19 September 2022

Your ref: SSD 10384 MOD 2

Subject: SSD 10384 MOD 2 - Sirius Redevelopment Design Changes - Advice on Modification

DWG. TITLE
Landscape Plan - LEVEL 05-07
PROJECT
SIRIUS SITE, 2-60 CUMBERLAND ST, THE ROCKS

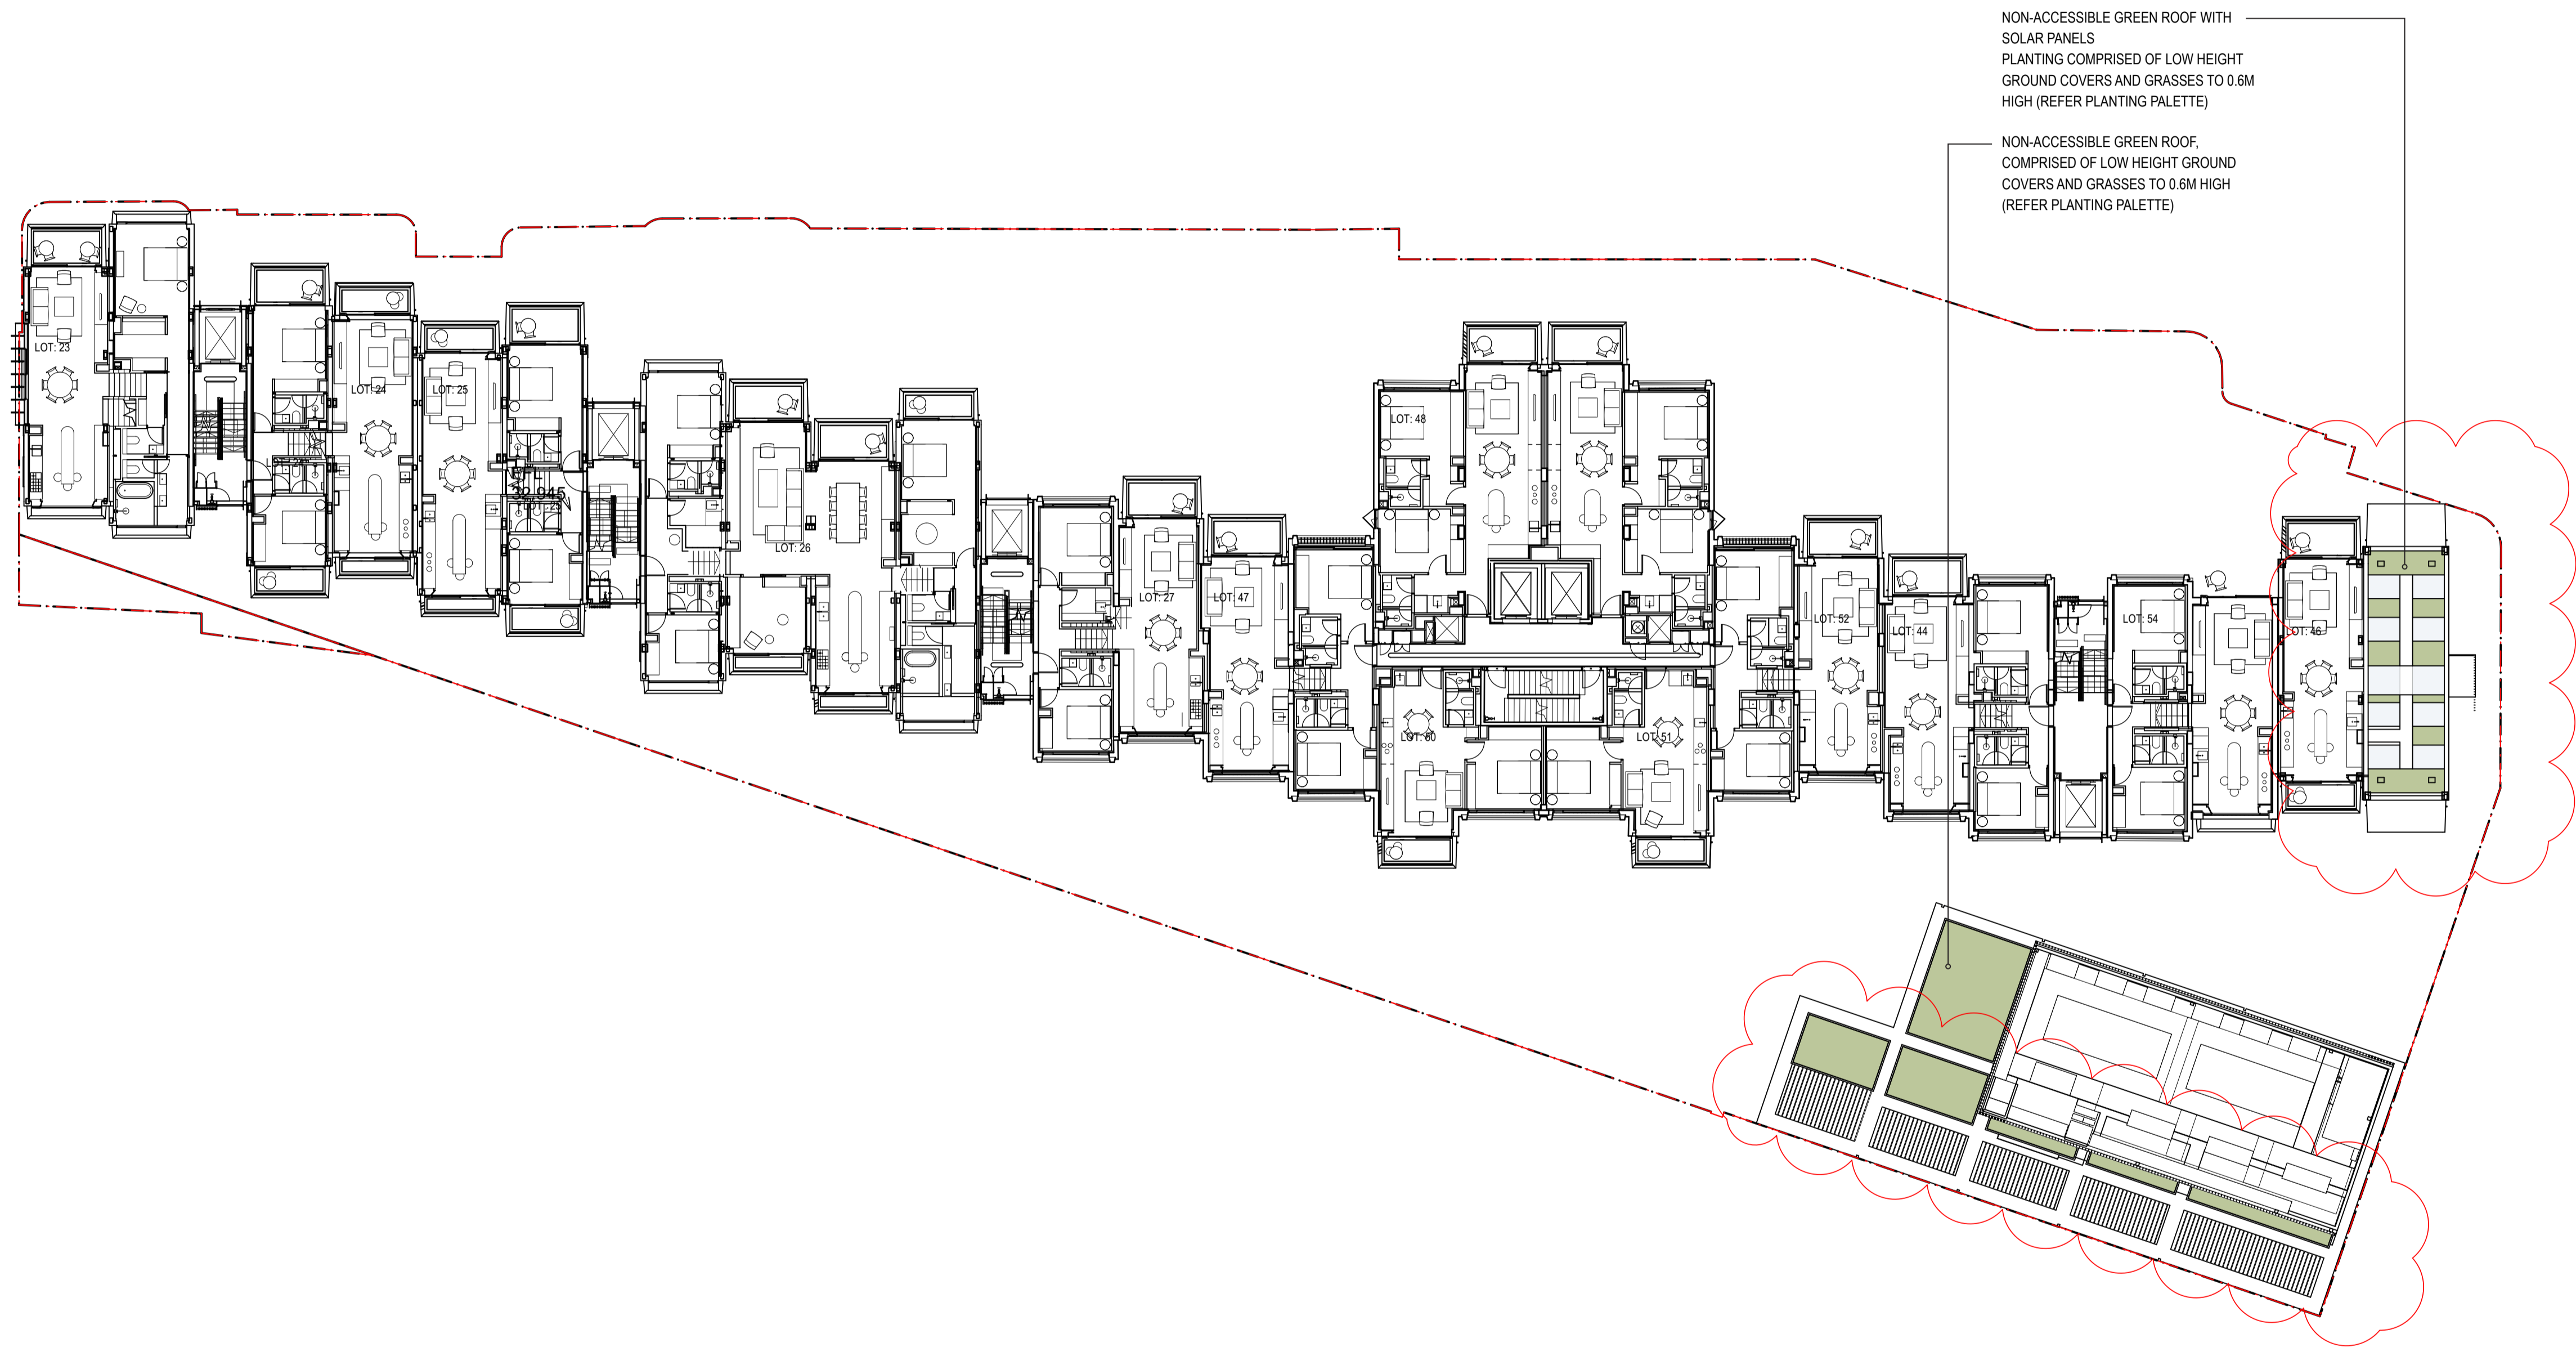
1. Greening to the facade over Cumberland St carpark entry on Level 5-7 appears to be growing out of concrete
2. Greening to the tower on the north and southern elevations, public through site link and facade edges on various levels

Clarification is sought as to whether these greening elements highlighted on the architect renders are intended and, if these landscaping elements are proposed, the architect and landscape design must make allowance for planters with adequate soil depth, climbing frames to facades. In addition, greening to facades will require maintenance access. It is requested that a preliminary maintenance strategy is prepared to confirm how all landscape elements will be safely accessed for maintenance post-construction contract.
